REQUEST	Current Zoning: I-1, light industrial Proposed Zoning: I-2(CD), general industrial, conditional
LOCATION	Approximately 12.12 acres located on the north side of Brookshire Boulevard between Oakdale Road and Caldwell Williams Road.
CENTER, CORRIDOR OR WEDGE	Center
SUMMARY OF PETITION	This petition proposes a 10,531 square-foot addition to existing buildings for a contractor's office with accessory outdoor storage. The request to I-2(CD) is allow the outdoor accessory storage. The site is currently developed with existing buildings containing 12,379 square feet and parking.
STAFF RECOMMENDATION	Staff recommends approval of this petition upon resolution of outstanding issues. The petition is inconsistent with the <i>Mt. Holly Road Special Project Plan</i> , which recommends light industrial for this property. However, the site is primarily surrounded by industrial uses on properties zoned I-1 and I-2.

PLANNING STAFF REVIEW

Planner: Claire Lyte-Graham (704) 336-3782

1 SITE LAYOUT & PAVING PLAN
C-1
Scale: 1" = 60'

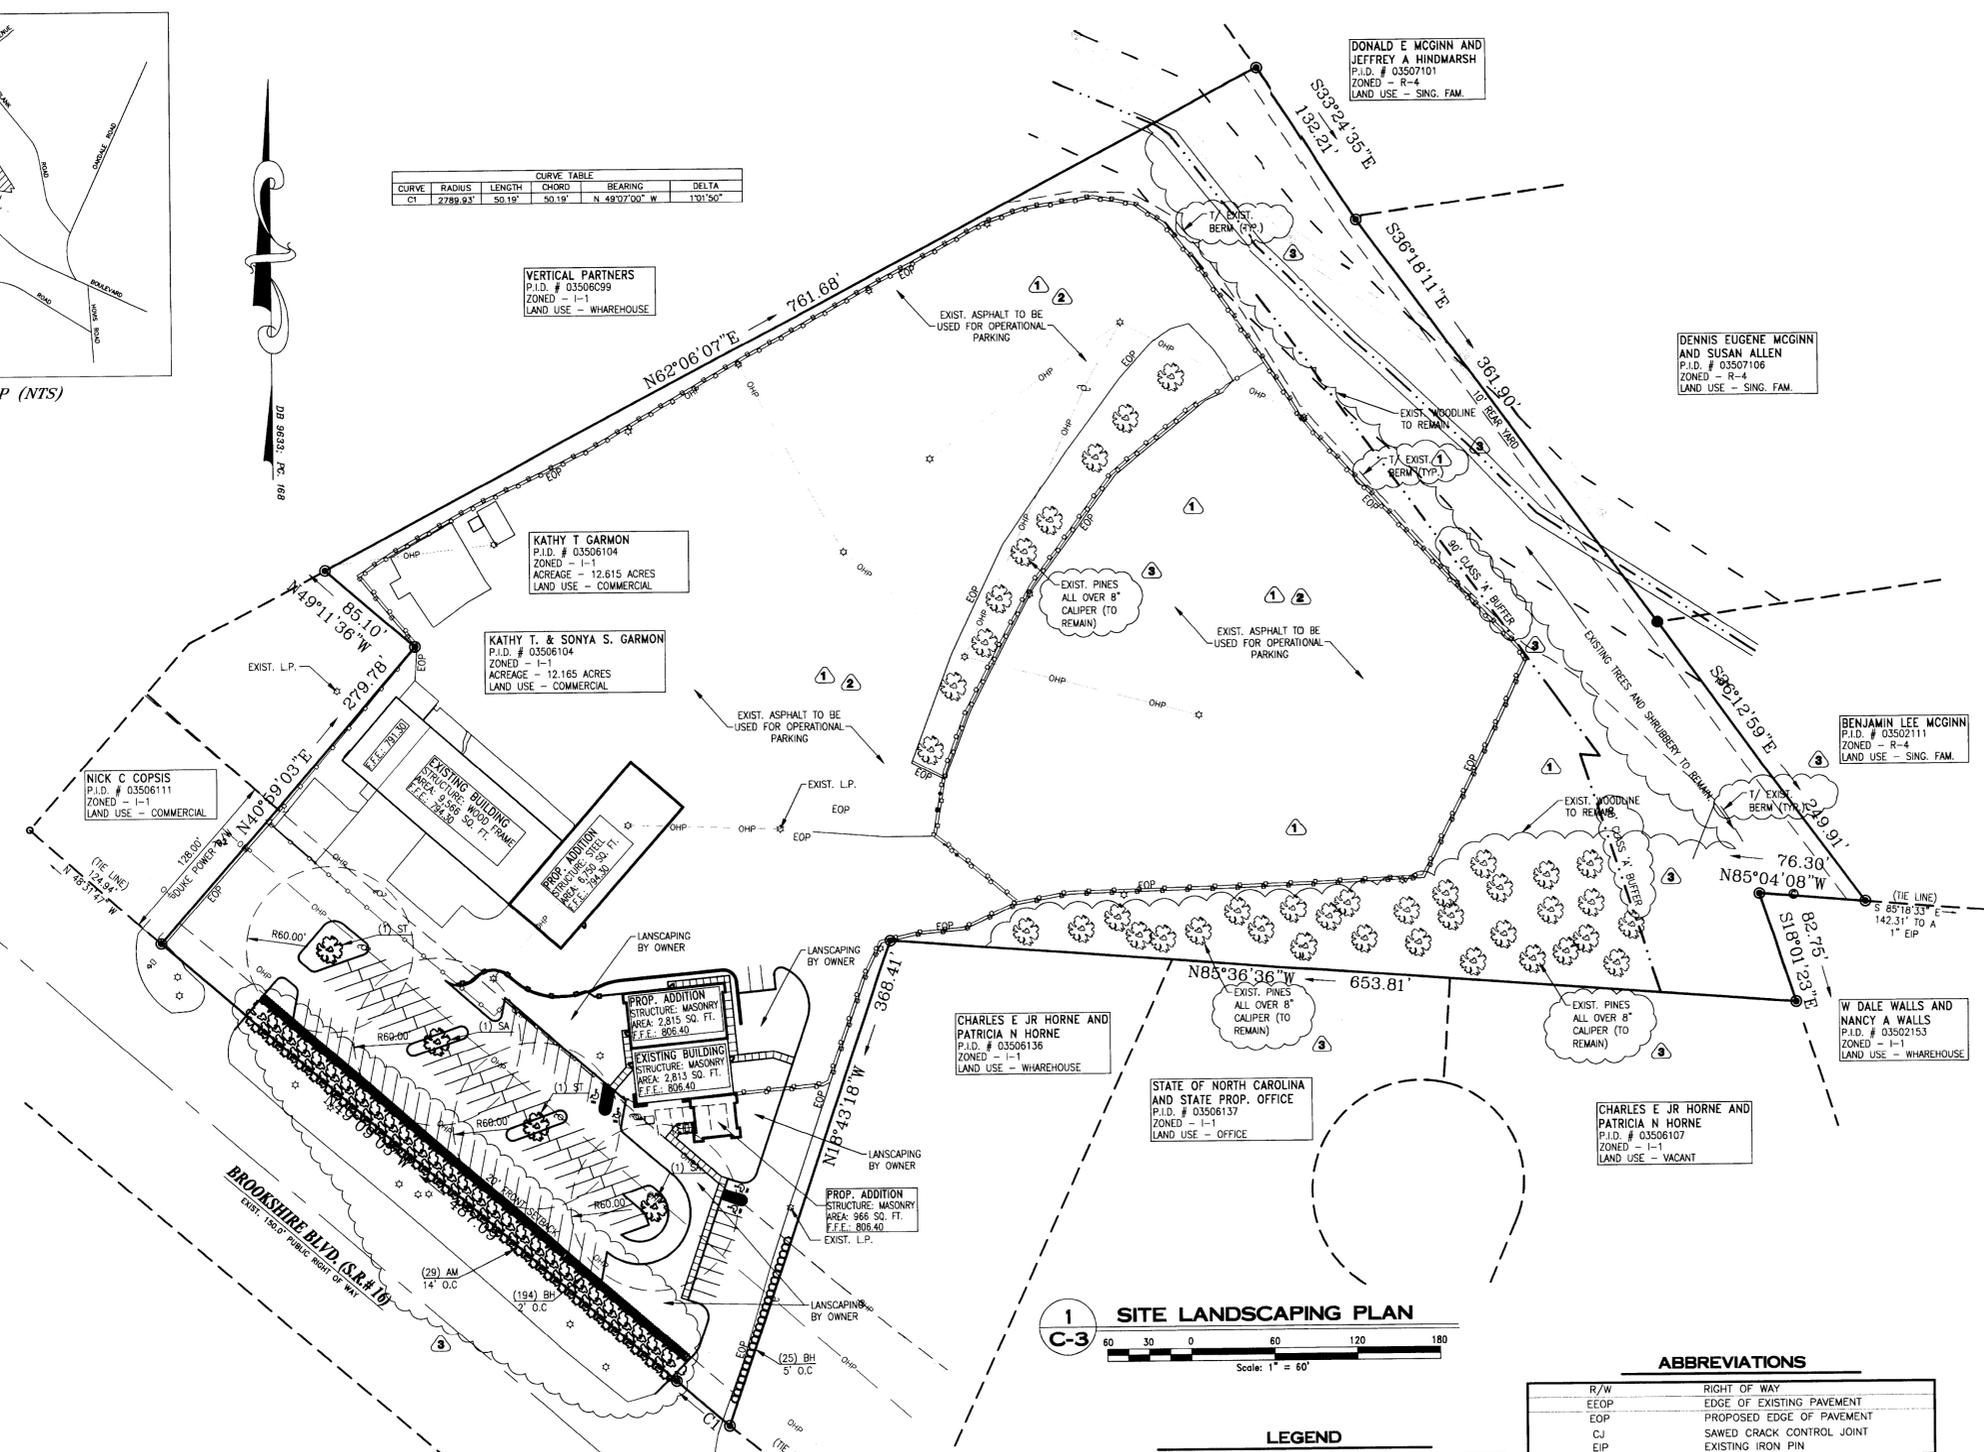
Realign the existing southern drive on Brookshire Boulevard in order to meet minimum standards;

Dedicate and convey 100-feet of right-of-way from the centerline on Brookshire Boulevard; and

Provide adequate sight triangles at driveway connections.

- **Storm Water:** Storm Water Services requests that the petitioner remove the existing storm water note from the site plan.
 - **LUESA:** States that development of this site may require submission of an asbestos Notification of Demolition and Renovation due to possible demolition or relocation of an existing structure or renovation of a load-bearing wall in an existing structure. In addition, Mecklenburg County Waste Services requests that the petitioner submit a Solid Waste Management Plan prior to initiating land clearing, demolition and/or construction activities.
 - **Site Design:** The following explains how the petition addresses the environmentally sensitive site design guidance in the *General Development Policies*.
 - Reduces the amount and improves the quality of storm water run-off by maintaining existing vegetation on site.
-

1. Amend the Site Summary section of the site plan to state existing zoning and proposed zoning.
 2. Provide a cross-section of the existing berm along the northeast property line. The petitioner should ensure the buffer meets the requirements of Section 12.302(8) in order to allow the reduction of the required 100-foot Class "A" buffer along the northeast property line to 90 feet.
 3. Provide a note on the site plan indicating the width of the landscape area screening the parking area from Brookshire Boulevard.
 4. The petitioner should show and label the required six-foot sidewalk and eight-foot planting strip along Brookshire Boulevard.
 5. Address all outstanding CDOT, LUESA, and Storm Water comments.
-
